**Subject:** CU-25-00003 Wind Ridge BESS & SE-25-00010 Wind Ridge BESS - Notice of Application

Bonneville Power Administration's (BPA) has had the opportunity to review an application for the Wind Ridge BESS Conditional Use permit & Wind Ridge BESS SEPA located at parcel# 17-20-14030-0006.

RE: CU-25-00003 Wind Ridge BESS & SE-25-00010 Wind Ridge BESS

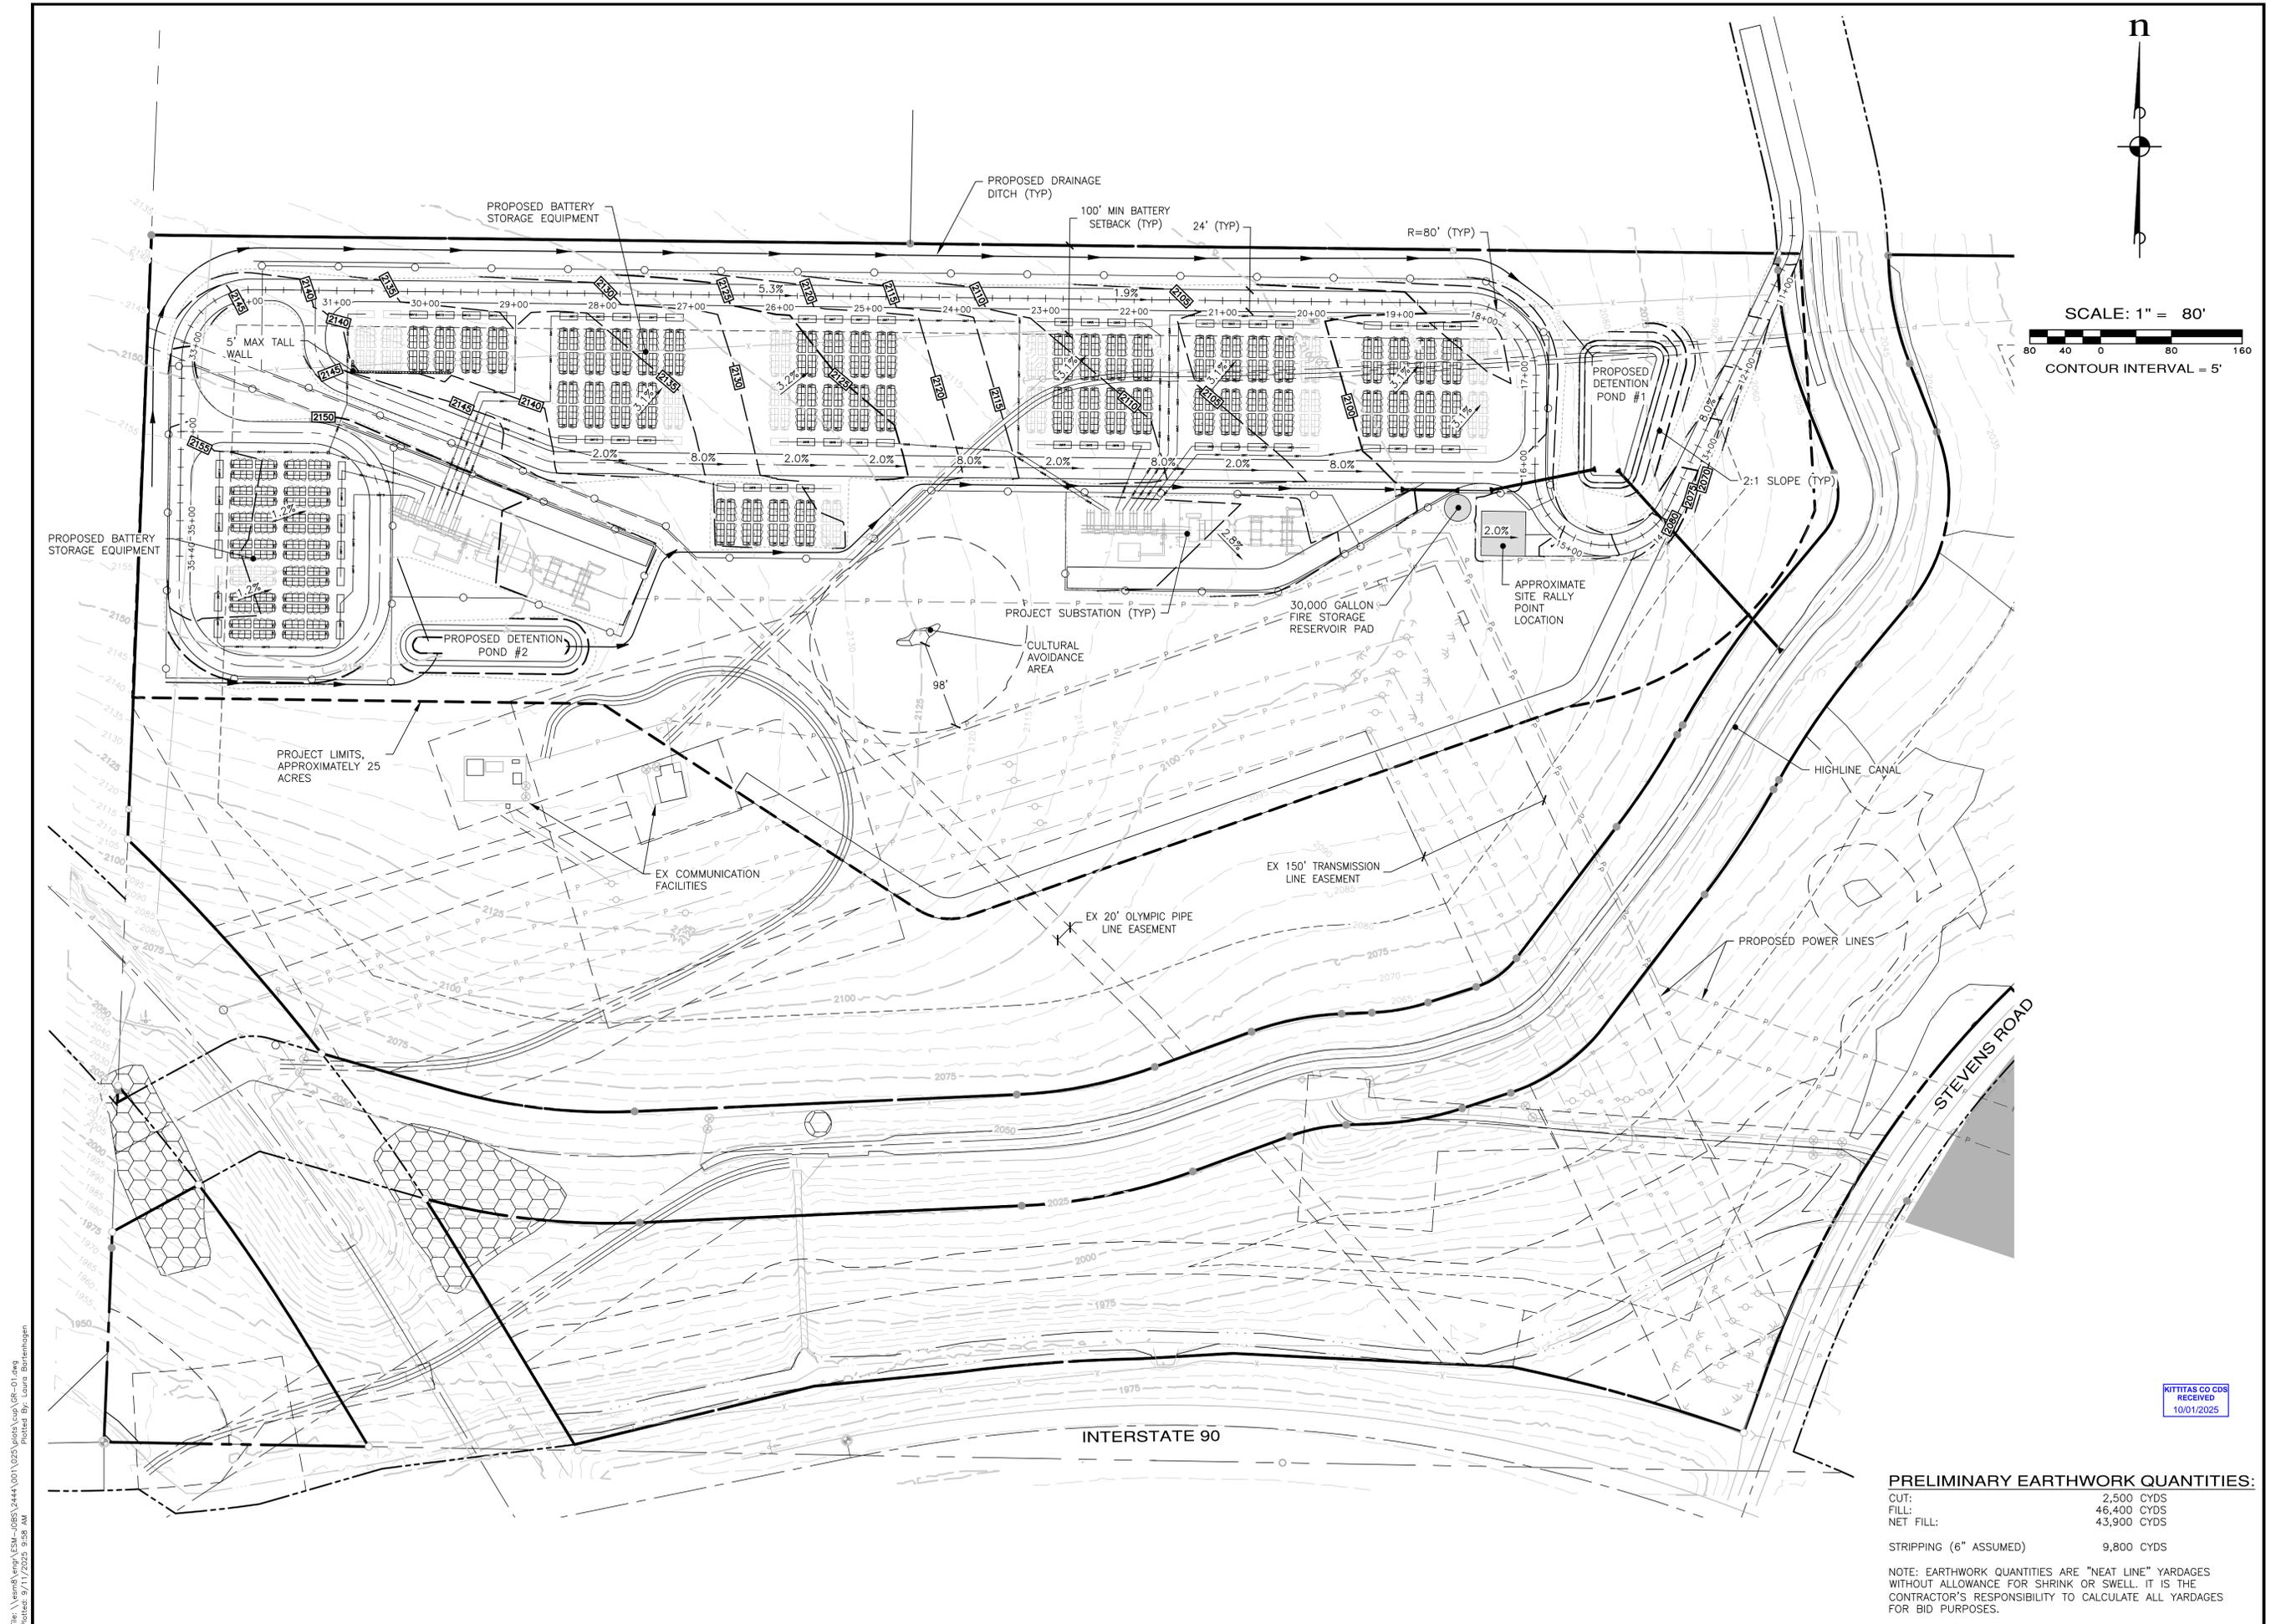
*Issue #5: Preliminary Site Plan shows Detention Pond Overflow Culvert leading directly into the KRD's North Branch Canal.*

The North Branch is owned in fee by US Bureau of Reclamation and as a result a modification to the right of way top to install this culvert will require a license from Reclamation. As the right to use, maintain and operate the right-of-way for the purposes of delivering irrigation water has been transferred by the United States to the KRD, KRD will recommend against any modification of the right-of-way for this purpose. This will have the effect of increasing the flow of water in the canal and KRD will have no control over the increased flow. This will severely negatively impact the operations of the canal and the delivery of irrigation water down canal from the point where the proposed pipe enters the canal. KRD will not allow contaminated water to enter the canal.
